MEMORANDUM

TO: All Staff
FROM: Justin Turnbull, County Surveyor 
DATE: April 25, 2019
SUBJECT: County Survey Review of Final Plat LPF-19-0003 (Palomino Fields – Div. 2)
(2nd Review)

Surveyed by LMH Scale 1" = 300'
Drawn by Tml/FCS Sheet 1 of 5
Checked by FCS Project No. 18146

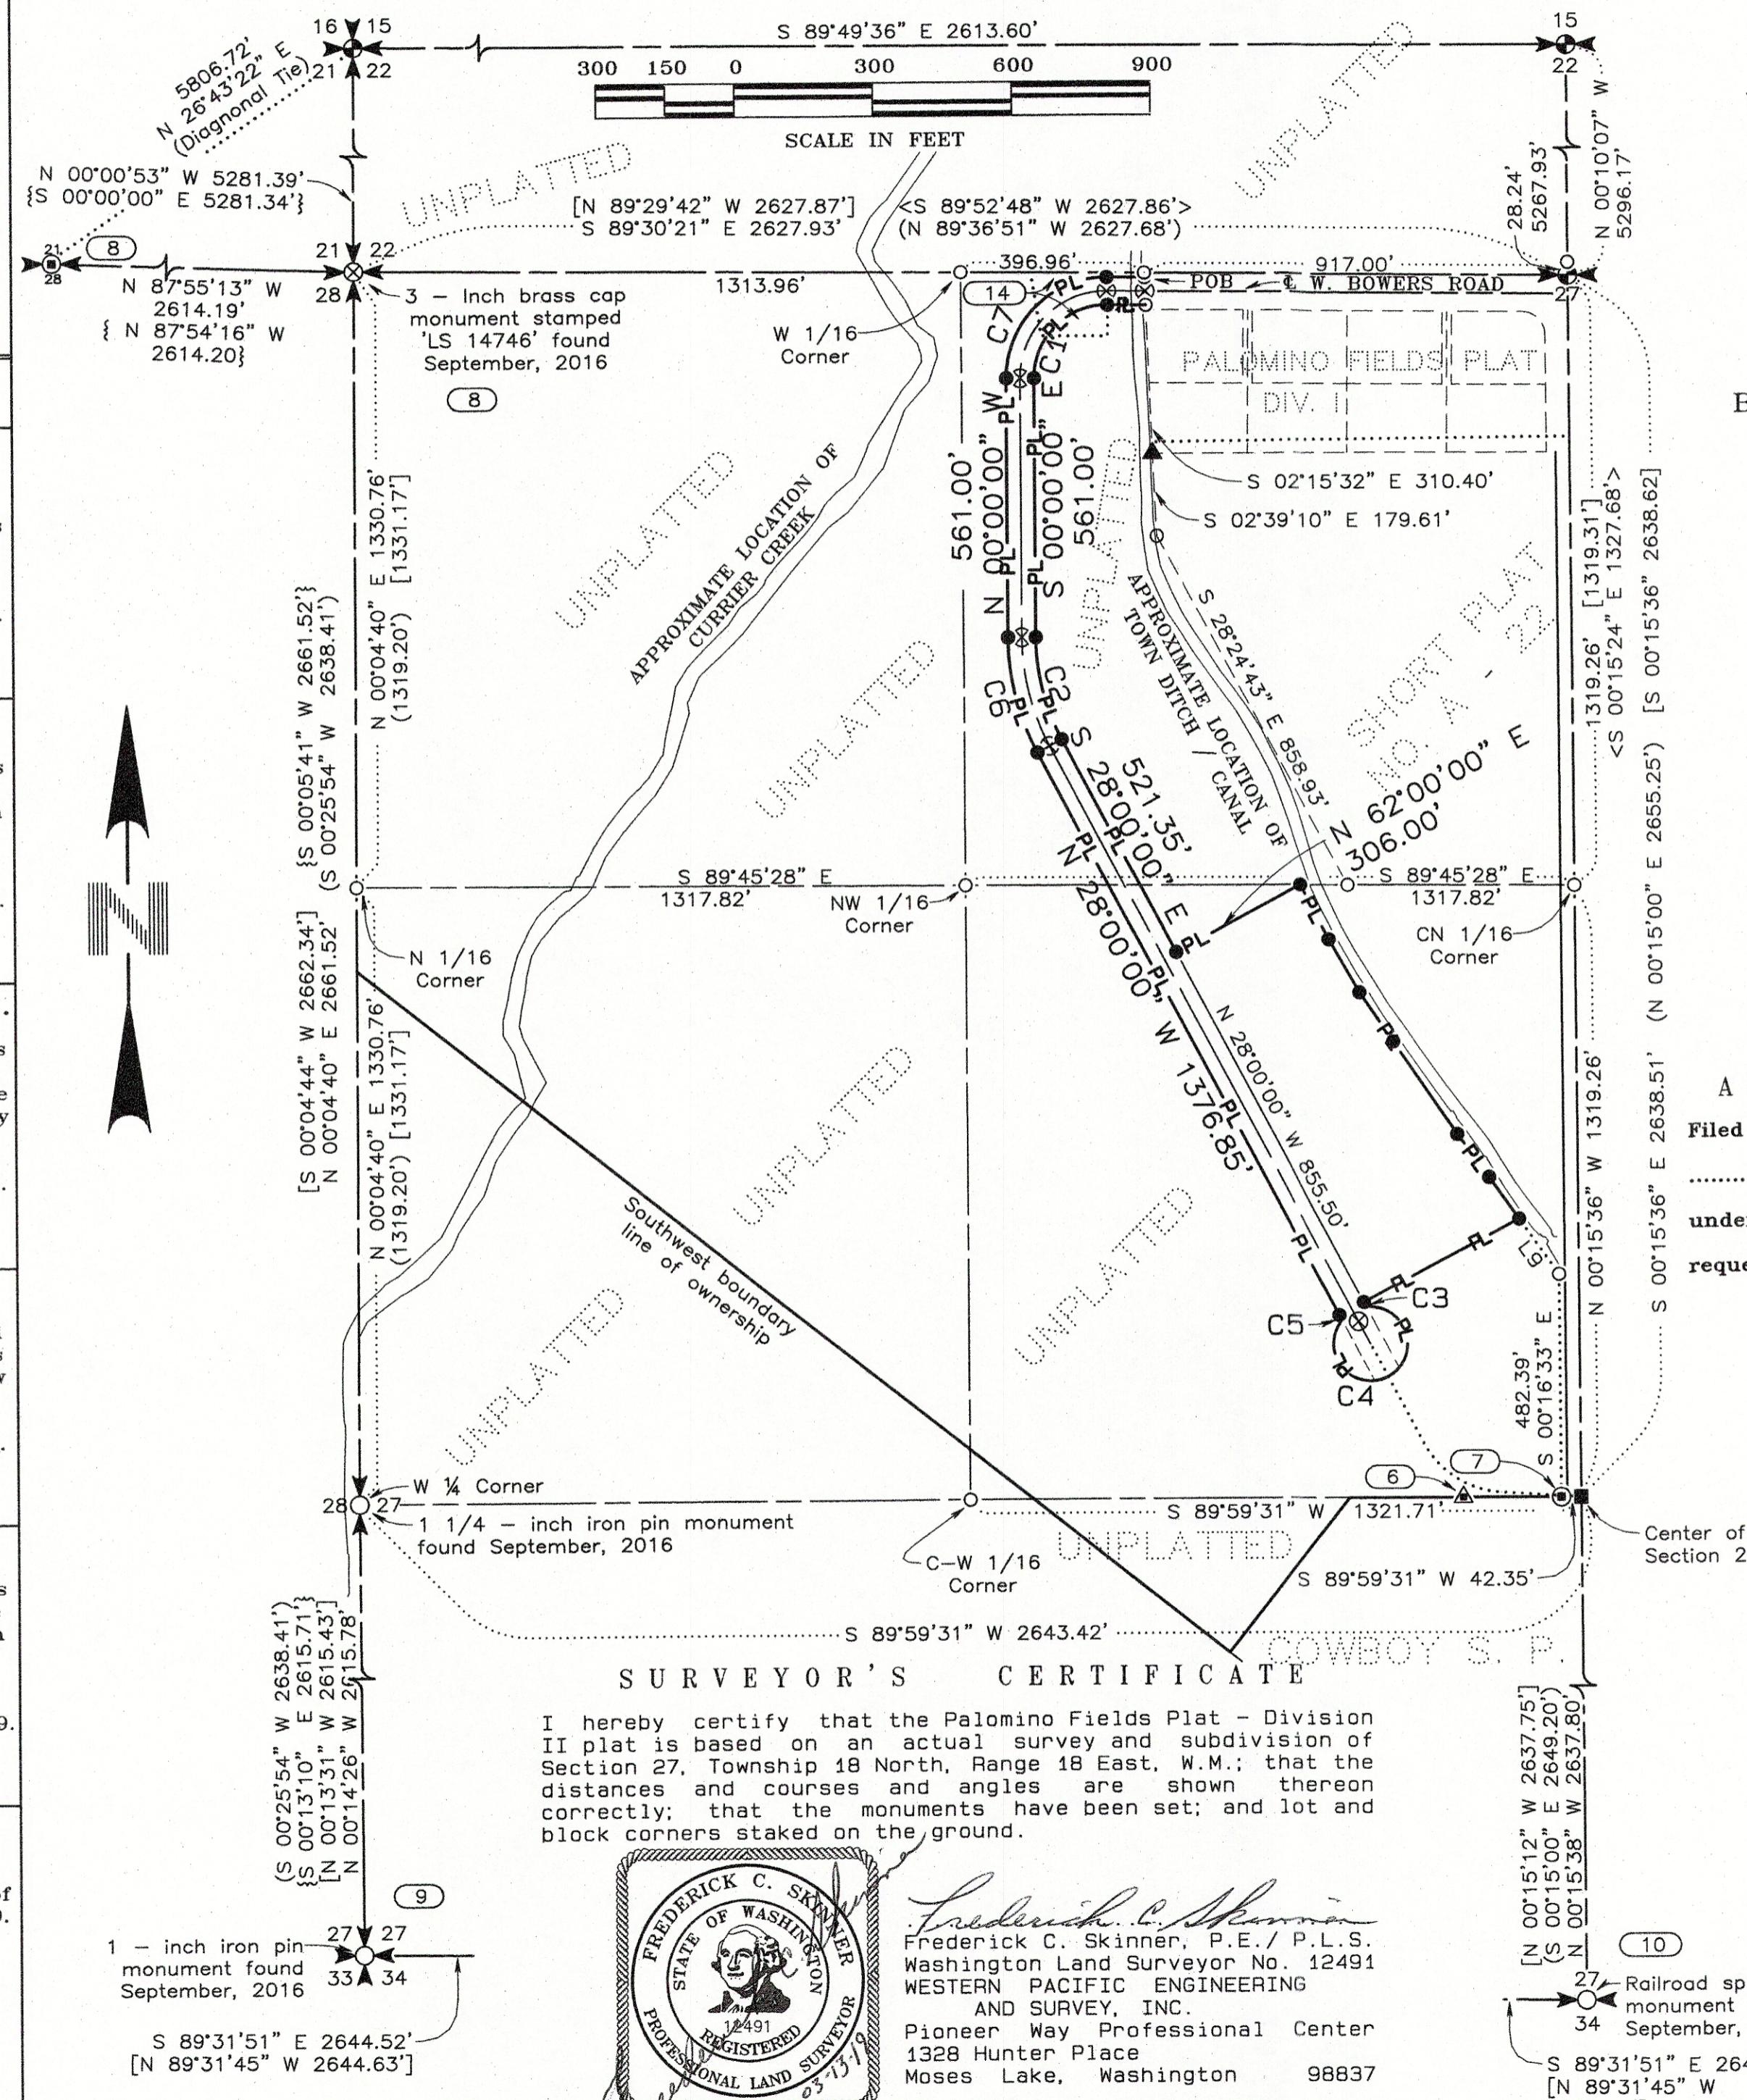
Sheet 1

1. The South line of Tract D – dimension 458.32 is obscured.
2. The North line of Tract B – dimension 396.96 is obscured.
3. The North line of Section 27 – dimension 2627.68 is obscured.
4. The South line of Tract C – dimension 480.82 is obscured.

Surveyed by LMH Scale 1" = 100'
Drawn by Tml/FCS Sheet 2 of 5
Checked by FCS Project No. 18146

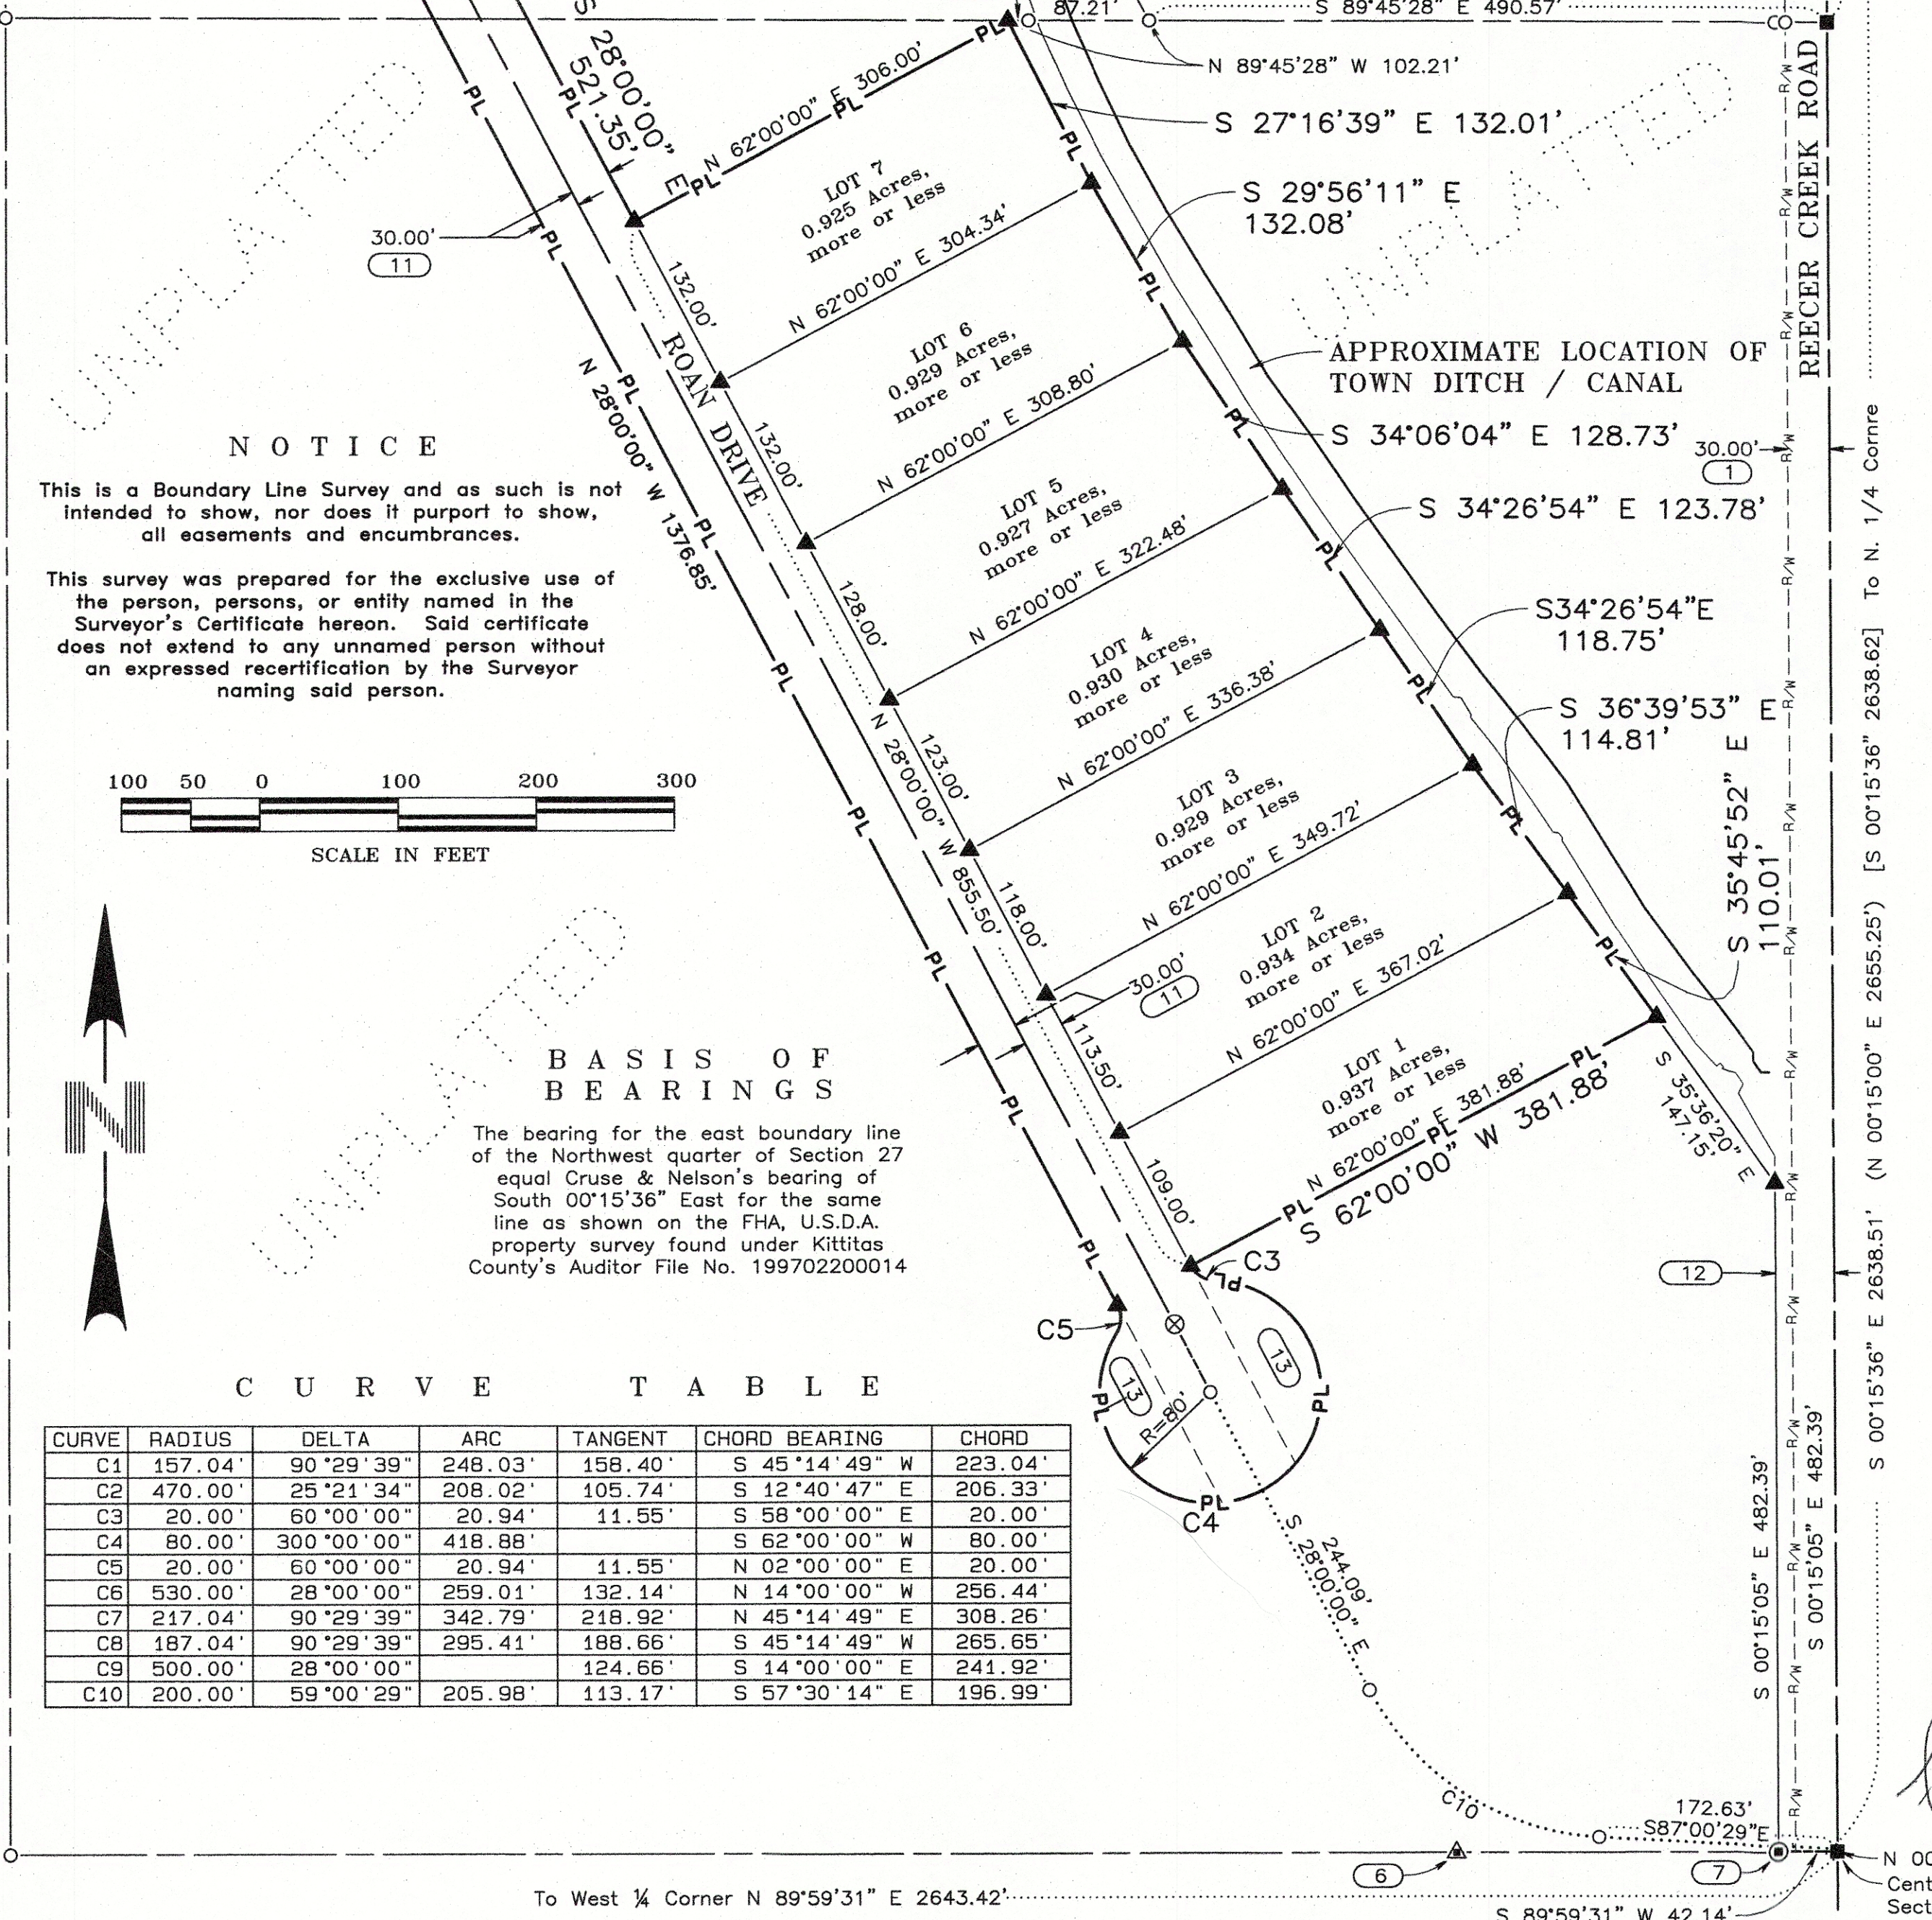
Sheet 2

5. Spelling error “conre” on N-S center section line.
6. Spelling error “Dlitch” in town ditch description.
7. The Easement (Note 13) is an easement within the road right of way, rather than an easement within Tract D. While not incorrect, it is assumed that the purpose of the temporary easement is to return the land to private interest once the road completes a loop, and therefore not requiring the cul-de-sac.
8. The delineation of “N00°15'36"W, 1.82 is unclear is to what is being dimensioned.
9. Dimension C24 is obscured. (Also occurs on sheet 3)
